## Fire Marshal Division

**Re: Harnett Health Lillington Medical  
7 E. Duncan St.  
Lillington, NC 27546**

**Application Number BCOM2007-0005**

1 LS LIFE SAFETY - EGRESS PLAN
 SCALE: 3/16" = 1'-0"

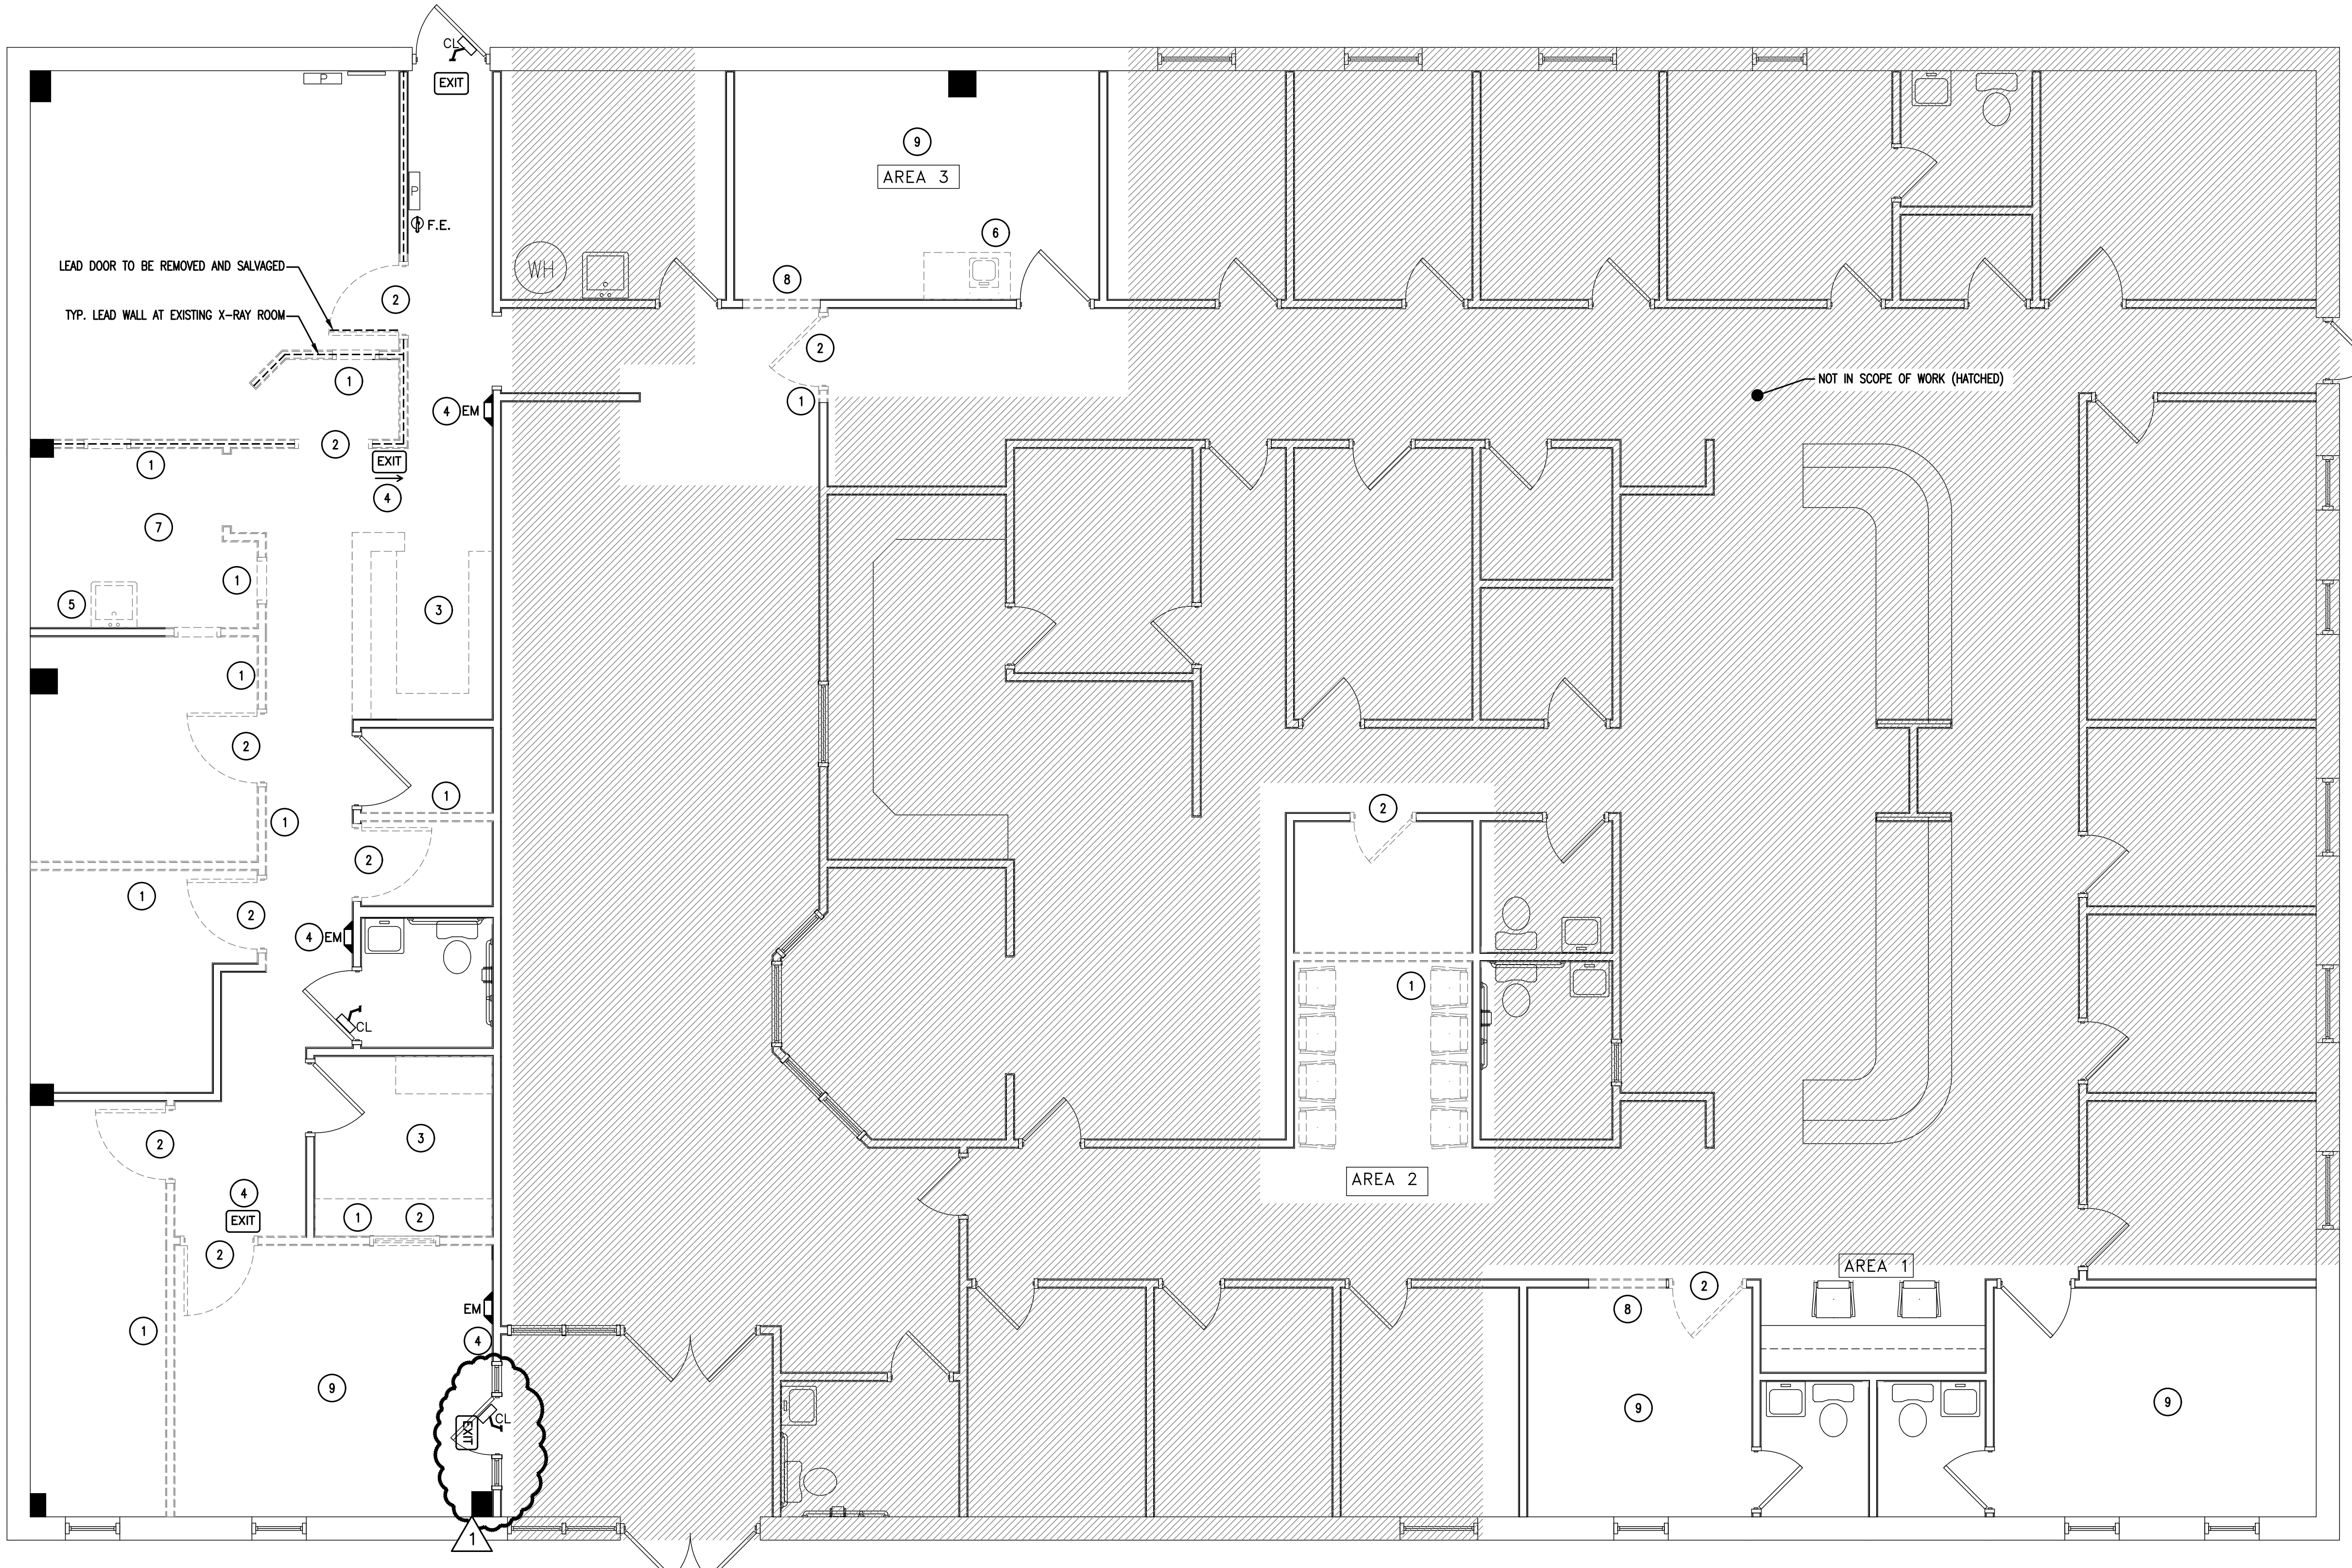
- **Fire Extinguishers**
  - Minimum of (1) 2A10:BC fire extinguisher shall be installed not to exceed 75' distance of travel.
  - All Fire extinguishers shall be properly mounted and tagged by a fire extinguisher company.
